AMENDED PLANS RECEIVED
DATE 18/05/12

8 Parsonage Avenue
Ribchester
PR3 3ZH

Proposed Plans and Elevations

PG2011 - 02 REV E

PG2011 - 02 REV D

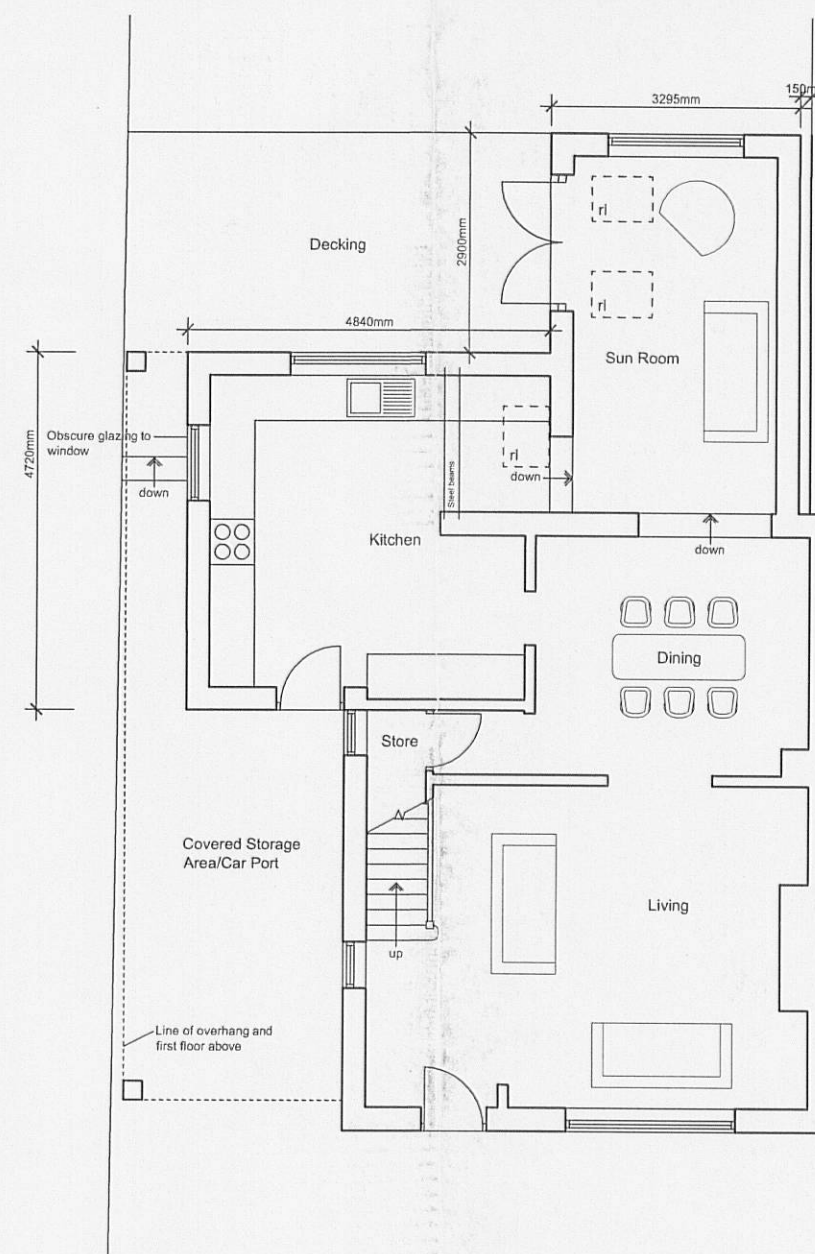
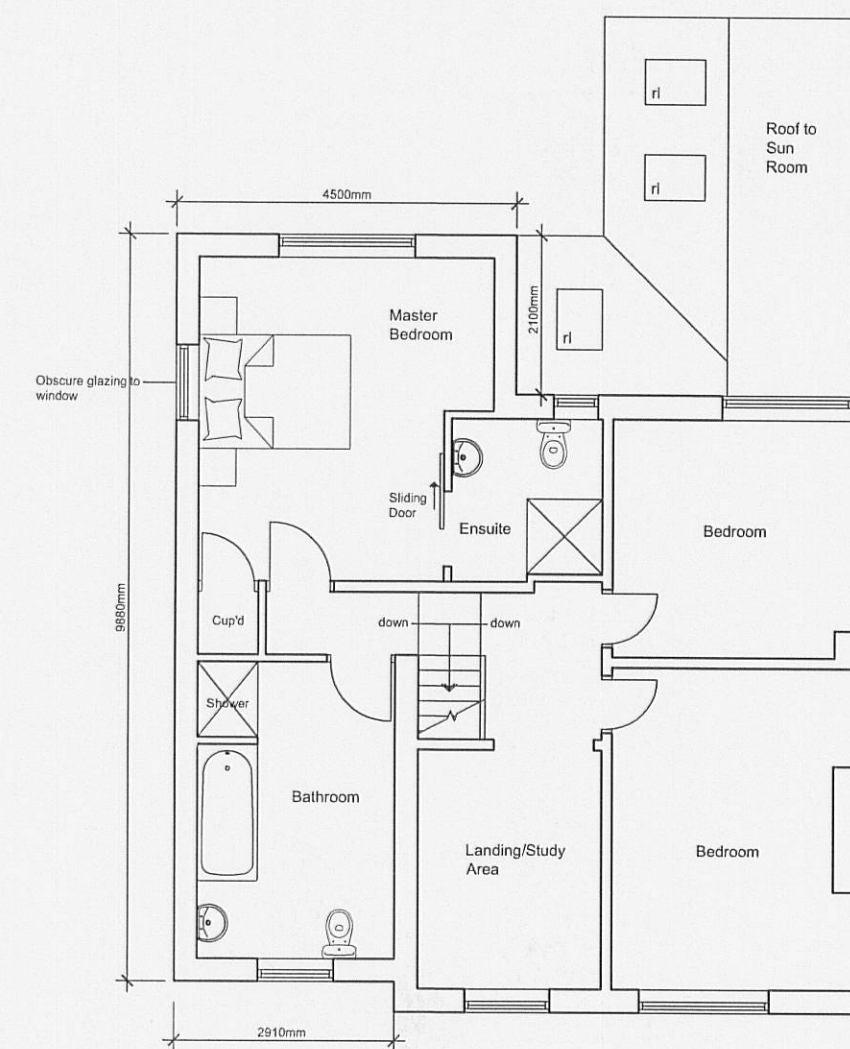
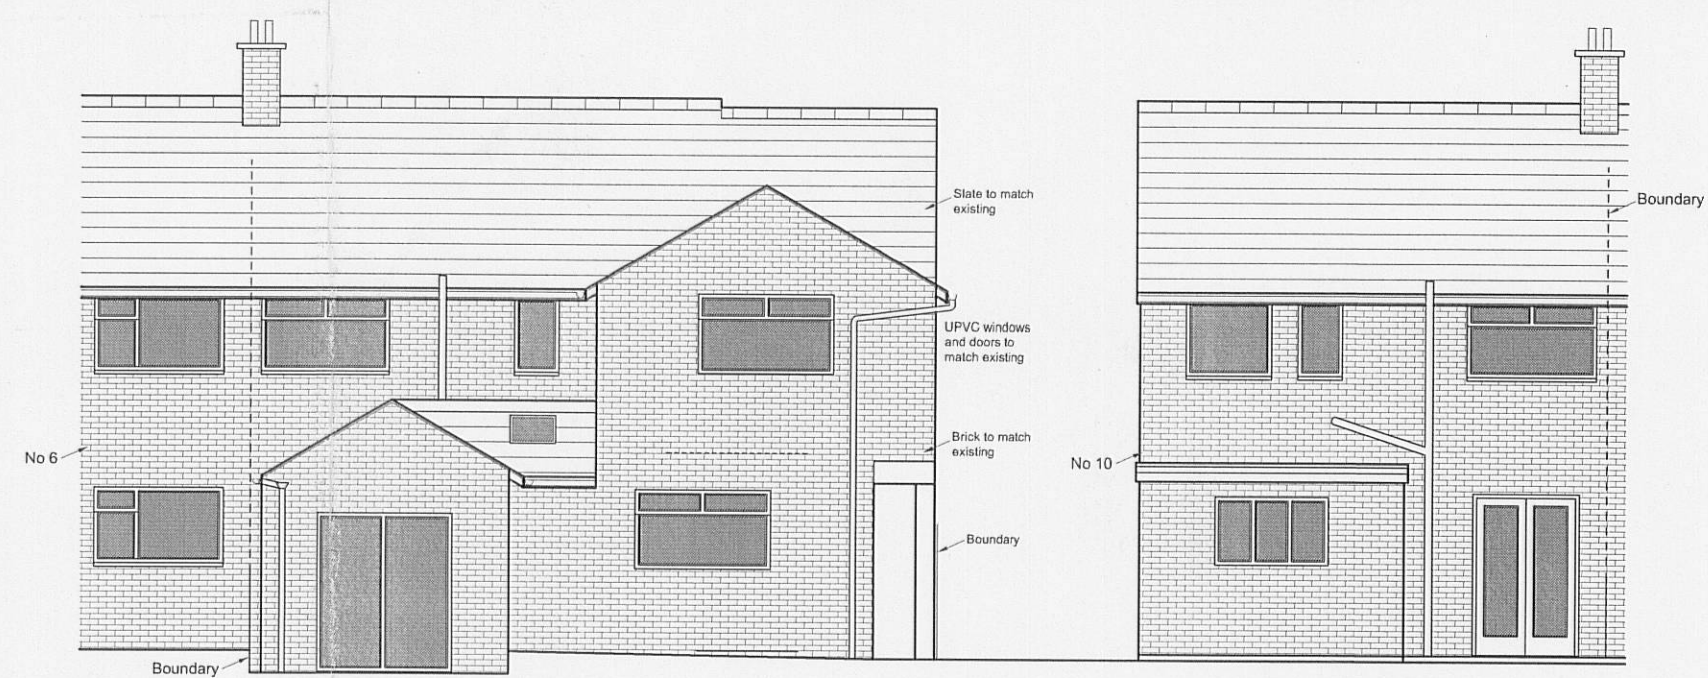
REVE - Altered as requested by planning officer. Width of side extension reduced and eaves detail altered to prevent the gutter overhanging the boundary. 17/05/12 LFG
